**REQUEST**

Current Zoning: N1-A (neighborhood 1 – A)  
Proposed Zoning: UR-2(CD) (urban residential, conditional)

The petition proposes to allow a 14-unit townhome development on a vacant parcel located between Park Road and Wintercrest Lane and on the north side of Fairview Road.

Staff recommends approval of the petition upon resolution of the outstanding issue pertaining to site and building design.

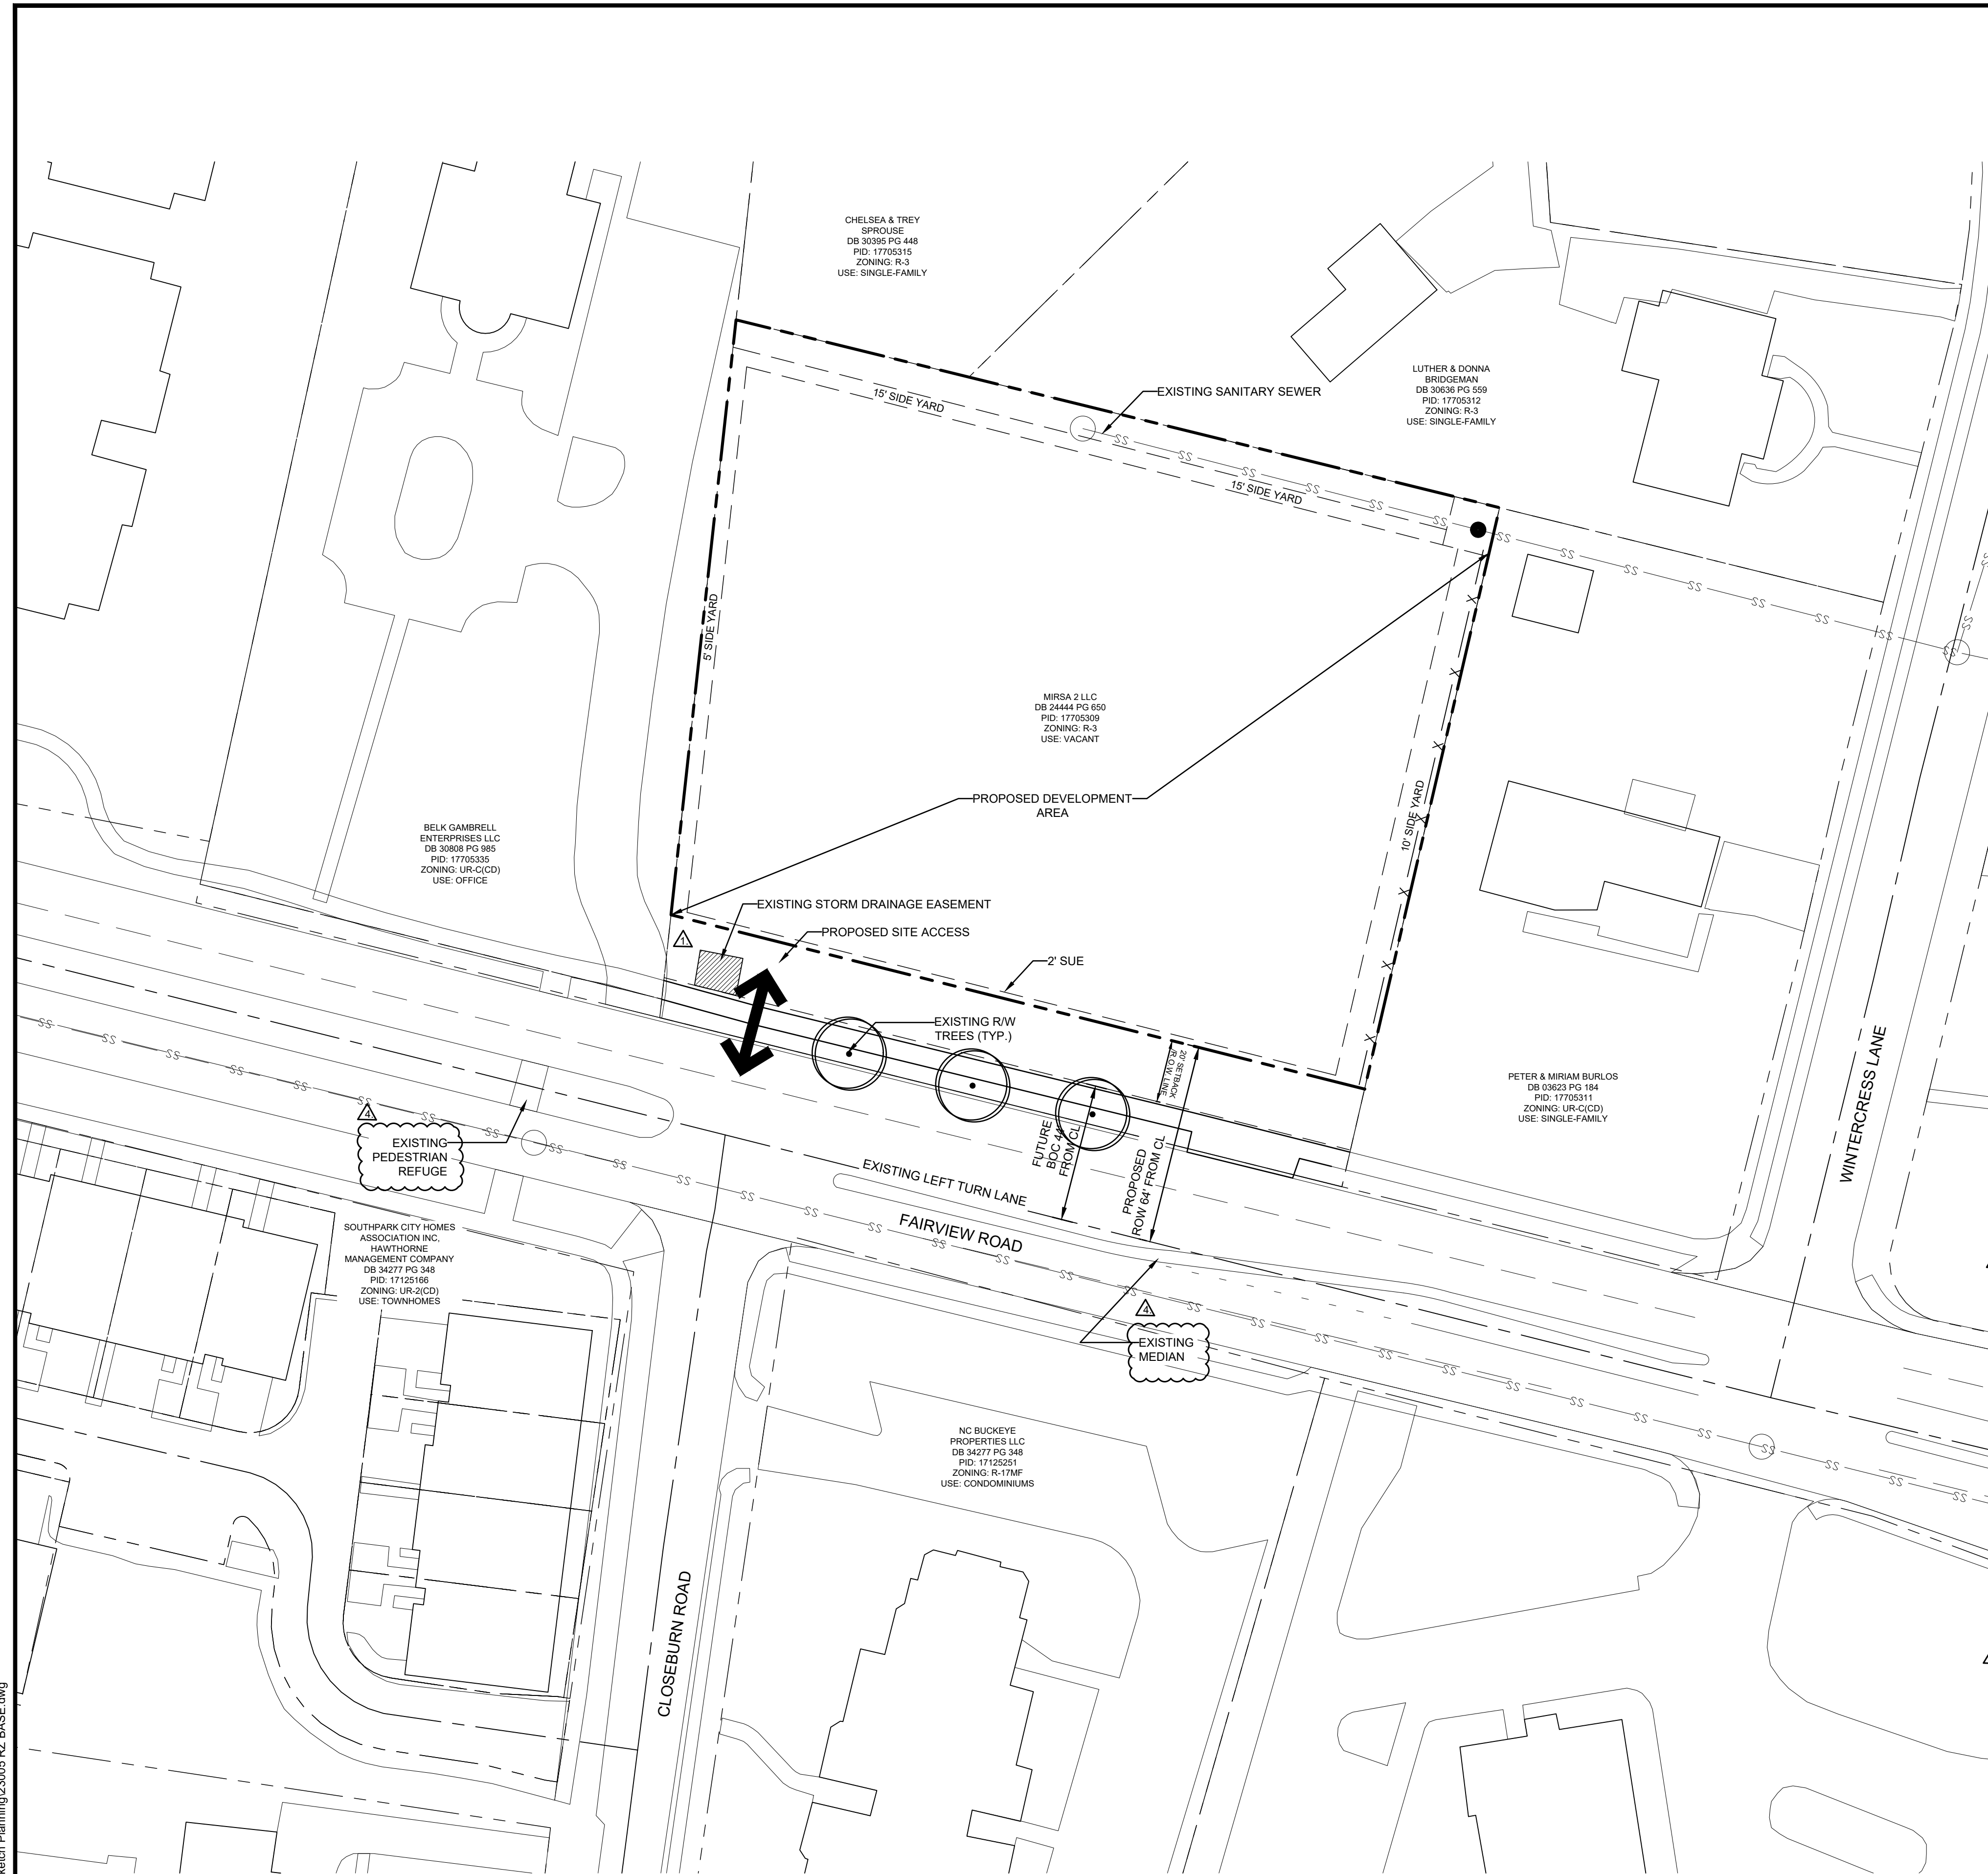
- ~~1. Limit the building height to 45 feet.~~ Addressed
2. Proposed eight-foot Class C buffer along east property line should be increased to 10 feet with language included it will not be reduced by 25%. **Update: There is a discrepancy between labeling on the site plan and Note V.2. Please revise so note matches the graphic depiction of a 10' wide buffer.**

- ~~4. Amend language to Limit the number of dwelling units in one building to four when fronting Fairview Road.~~ Addressed
5. The site plan shows a 15-foot sanitary sewer main line that runs parallel to a portion of the north property line. The petitioner needs to show and label the actual width of the sanitary sewer easement on the site plan. Provide a minimum 10-foot Class C buffer outside the sanitary sewer easement along the north property line. Show and label the buffer on the site plan and commit to this improvement in the development notes, specifying to not be reduced by 25%. **Not addressed**

**Petitioner's response: We are unable to make this commitment due to space limitations on site. We can commit to providing a buffer if the sanitary sewer easement is abandoned.**
